June 11, 2004

**RE: Volcano Plaza Shopping Center Grading and Drainage Plan  
Engineer's Stamp Dated 5-29-04 (J-11/D4)**

12" CMP SECTION

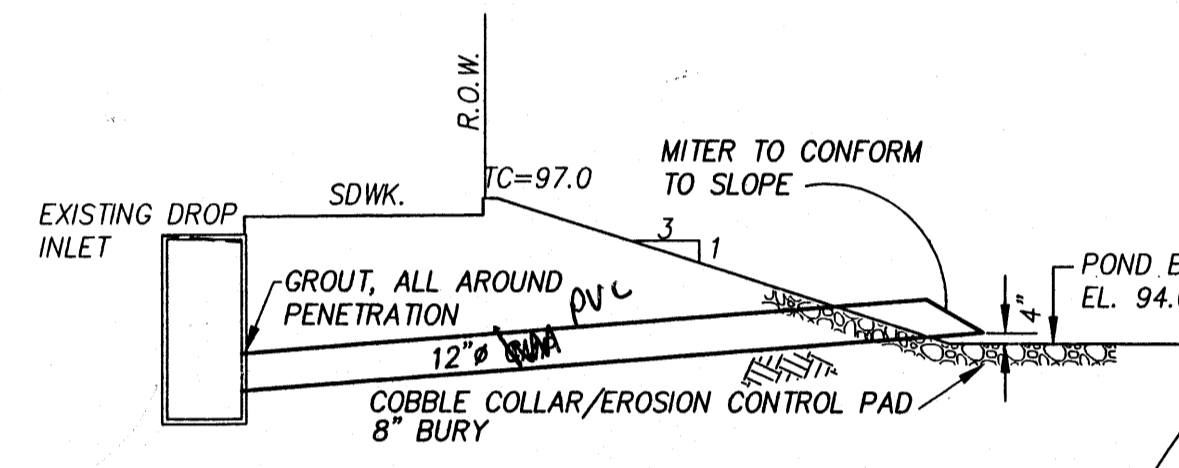
Based upon the information provided in your submittal received 6-1-04, the above referenced plan is approved for SO#19 Permit. Please note, PVC is required for the new 12" x 22' storm drain, CMP cannot be used for the storm drain. A copy of this approval letter must be on hand when applying for the excavation permit.
